Application for a non-material amendment following a grant of planning permission.

<input type="text" value="Proposed 61 bedroom care home"/>	
Reference number:	<input type="text" value="H16-0008-19"/>
Date of decision	<input type="text" value="19/04/2019"/>

Please describe the non-material amendment(s) you are seeking to make

Drawing Title
Roof plan - Proposed GA and Fire Strategy

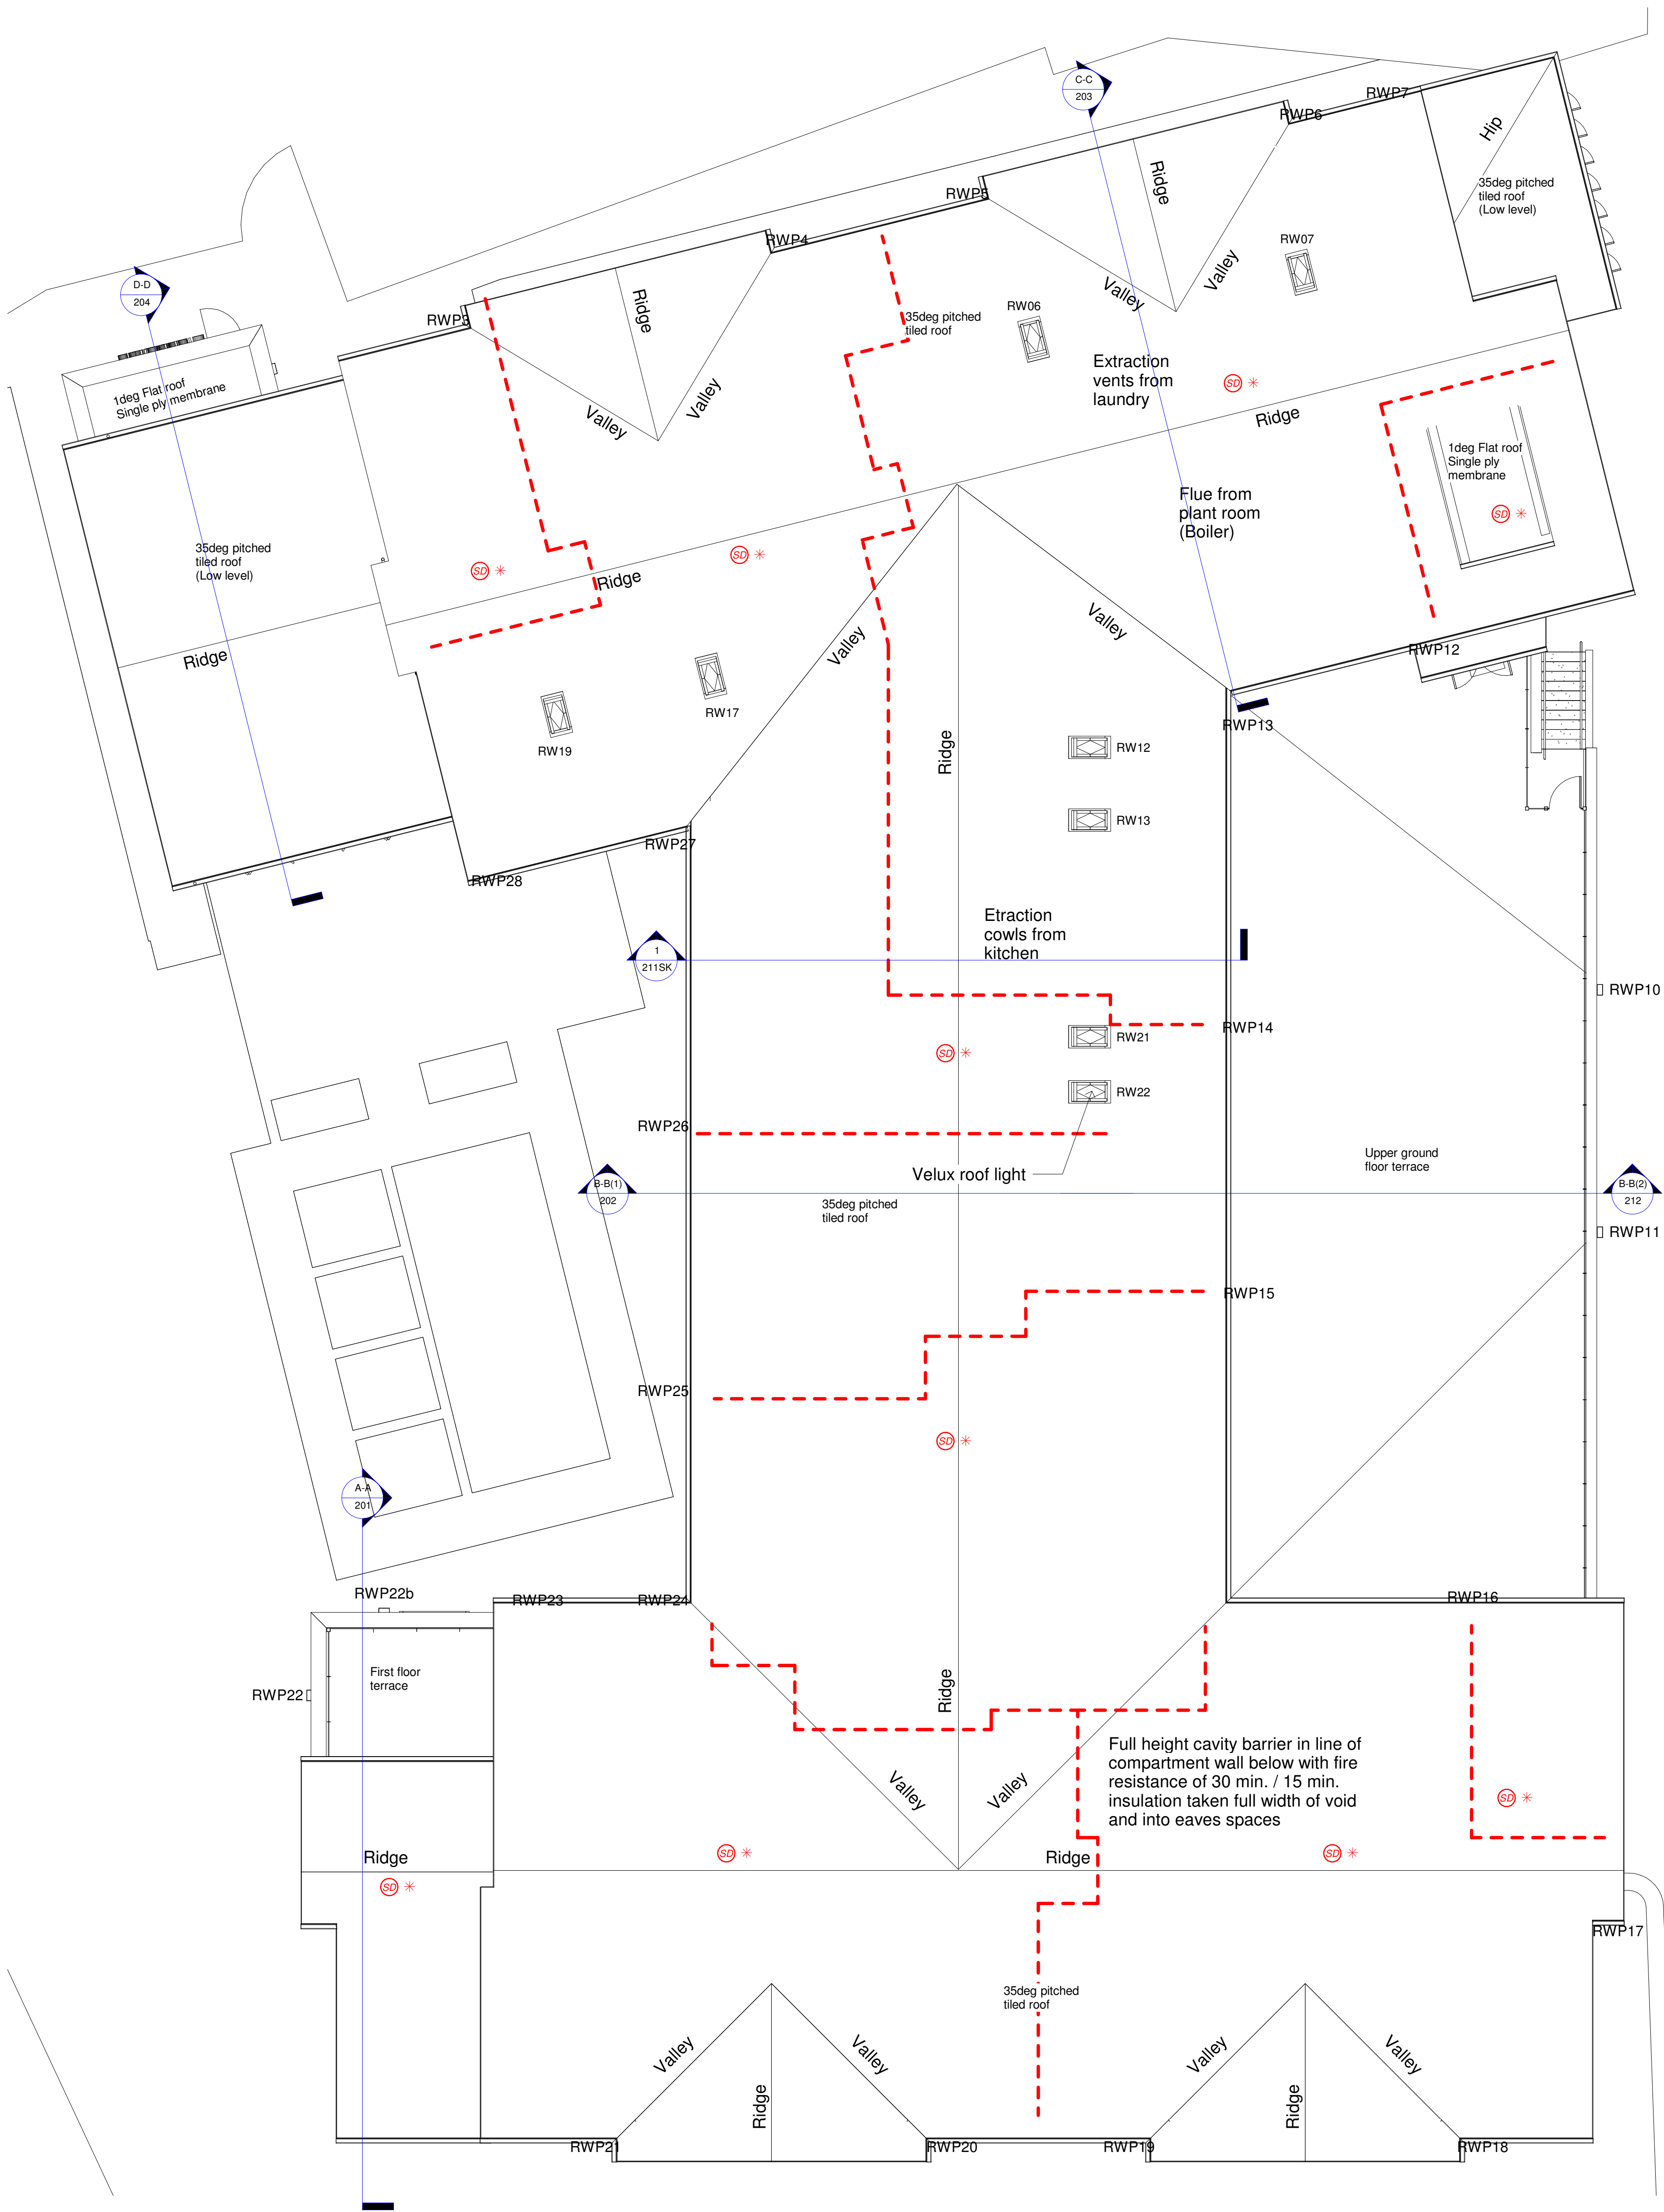
-Form of lift behind main entrance
-The entrance doors have been amended to allow for a COVID secure visiting area
-Inclusion of small Electrical cupboard within courtyard
-Landscaping generally amended
-Amount of roof lights reduced
-Bi-fold doors added to rear of entrance and Dayroom on elevation 6
- Cycle storage gates omitted
- Courtyard steps moved
- Brick type confirmed
